Significant Development Modification: 1. Upper Fort Street Public School

Application No: SSD - 10340 -MOD - 1.

Submission from :

Elevations

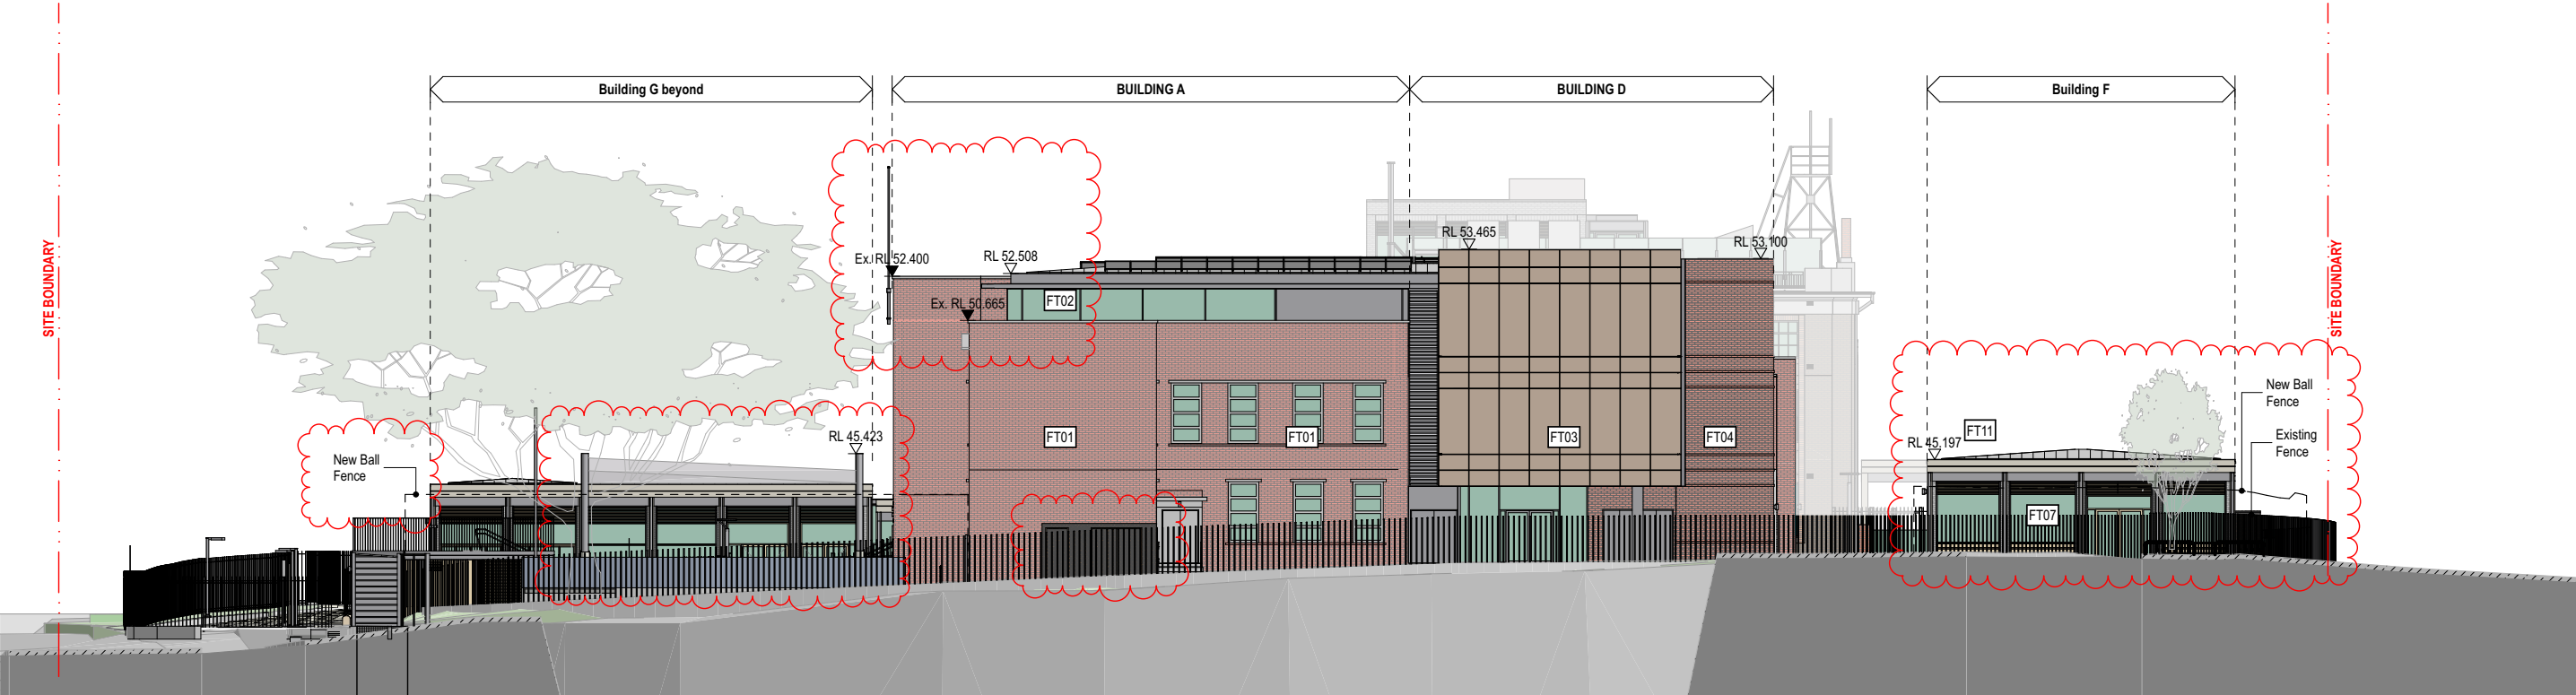
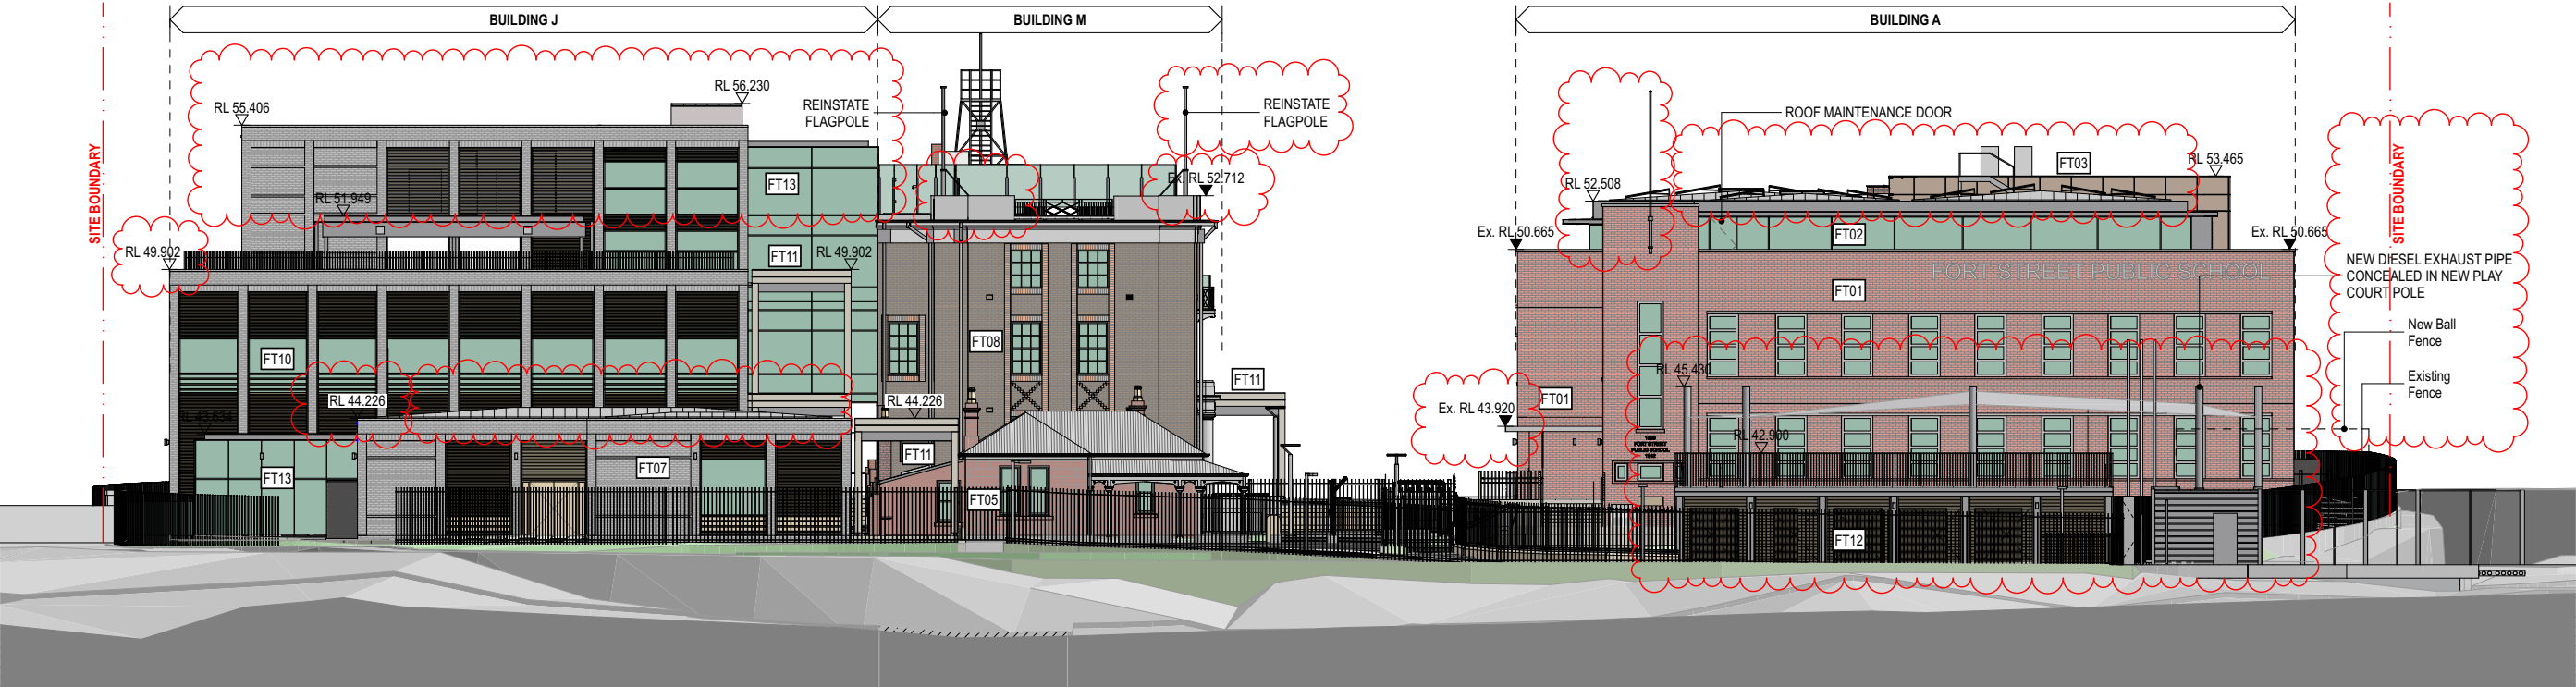
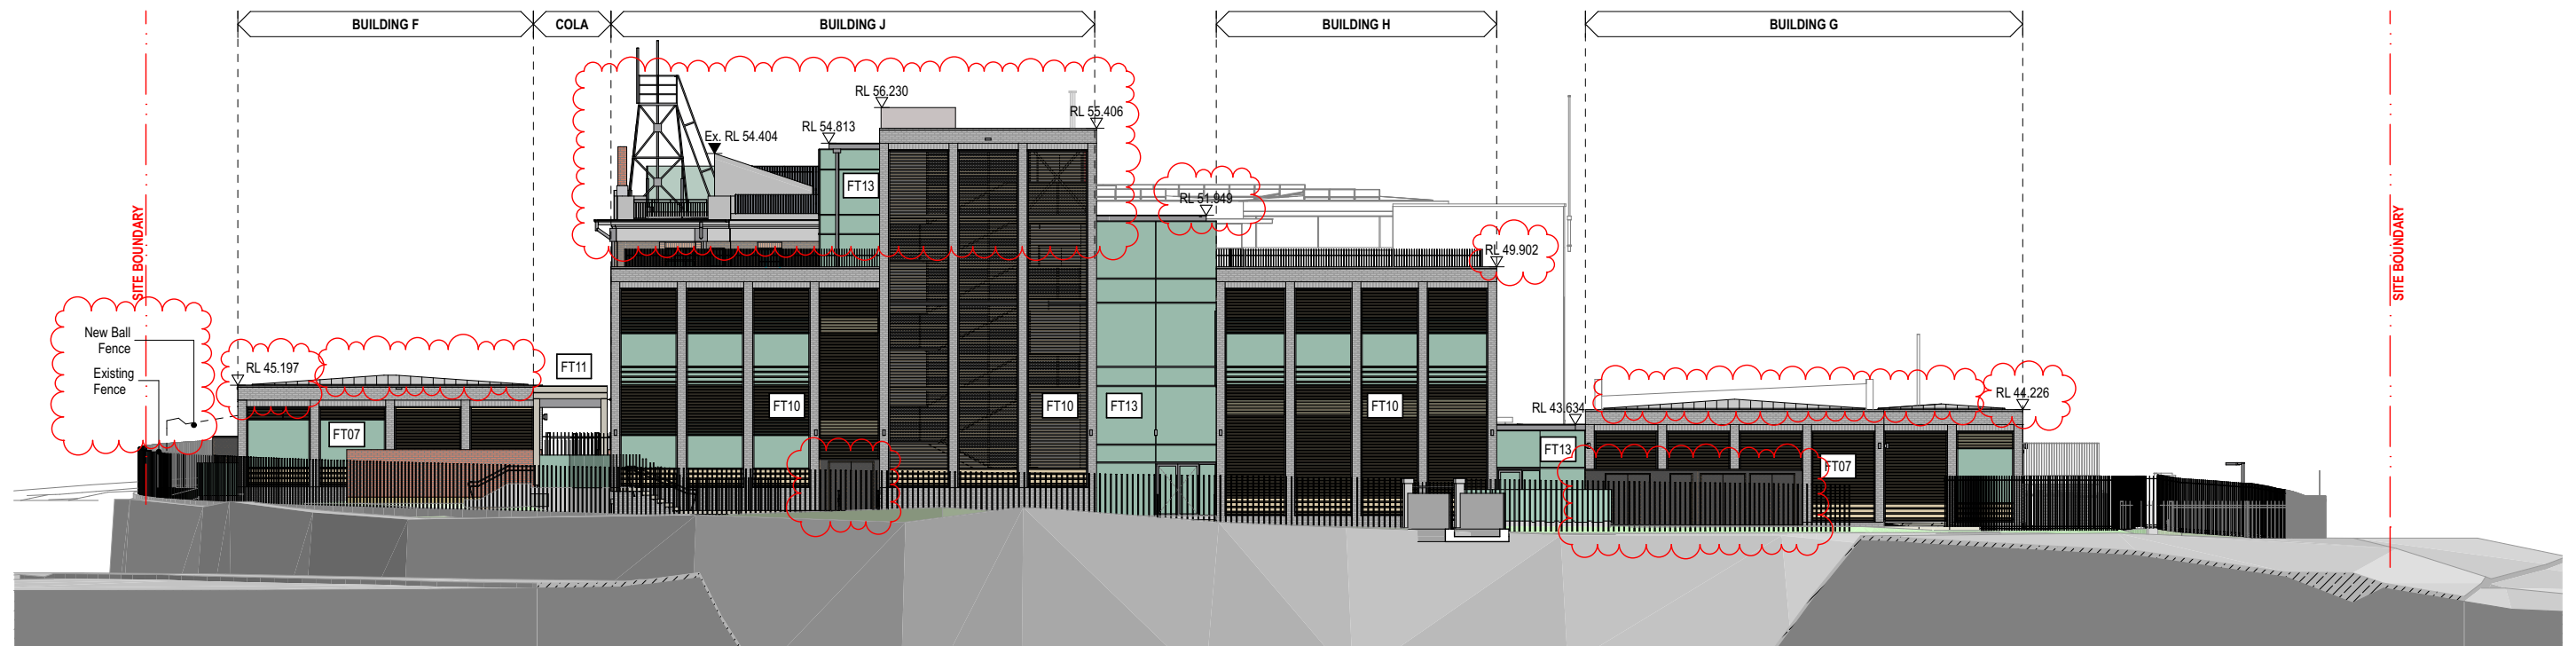
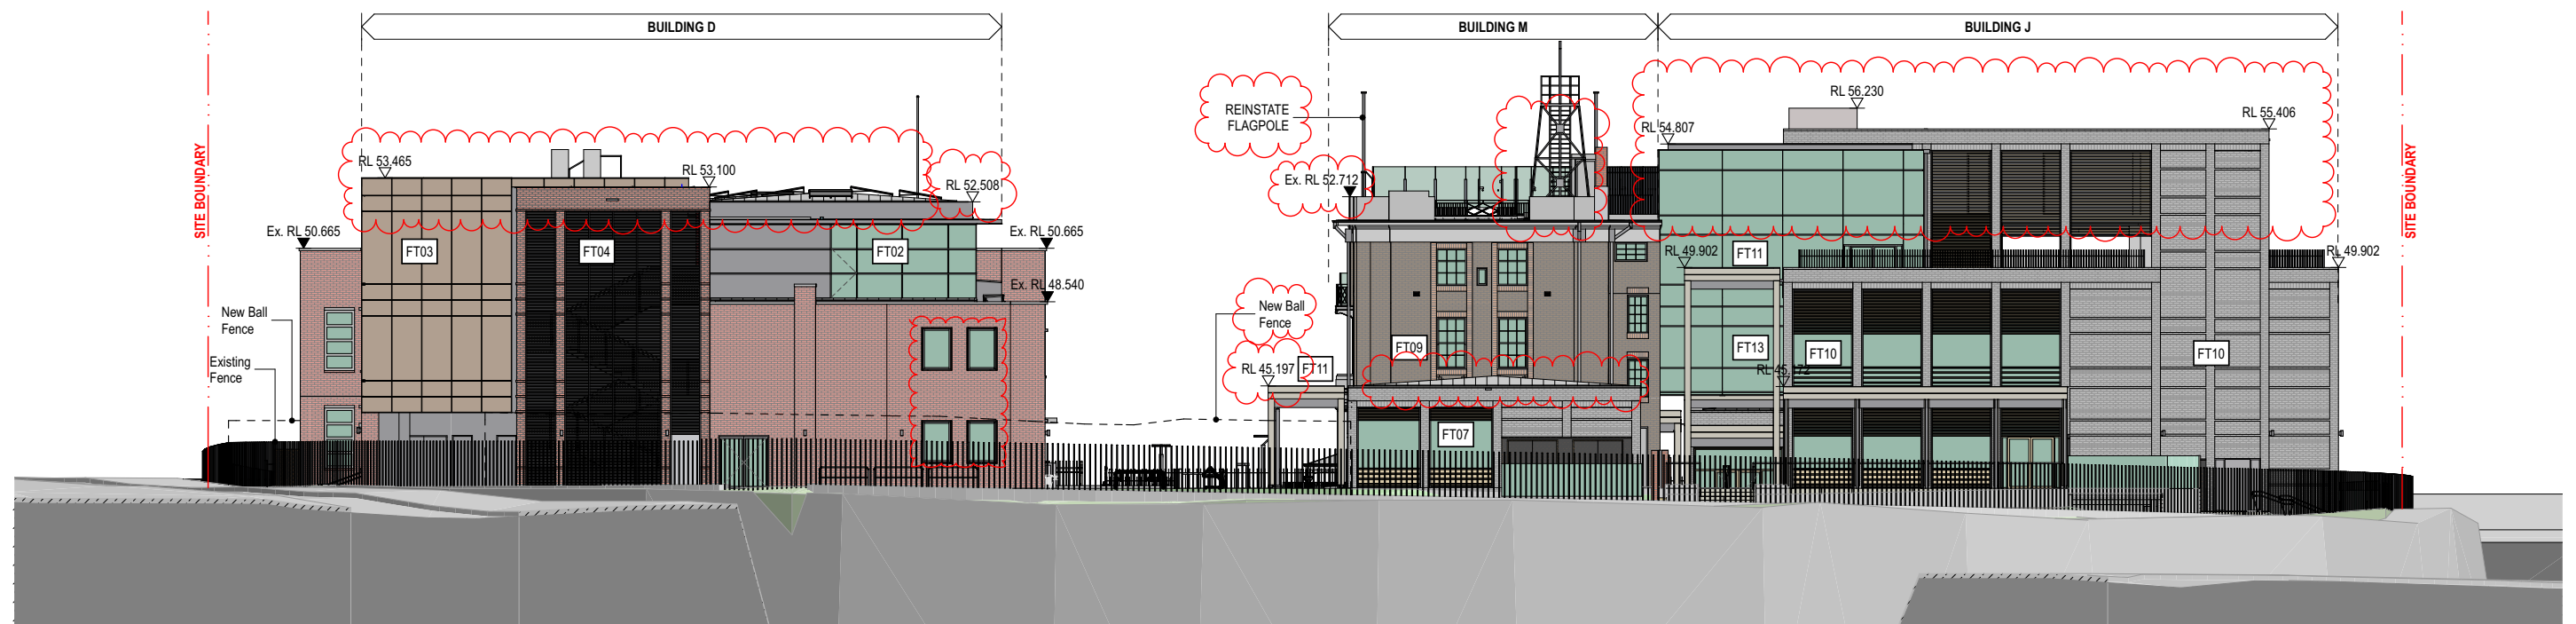
We object to this modification wherein Building J. is increased to height in double the current approval. (at height of Met. Build.)

Better design and further detailed effort should be employed to prevent additional height and bulk of building J. Excessive height on the most important site left on Sydney Harbour foreshore could be a sorry precedent.
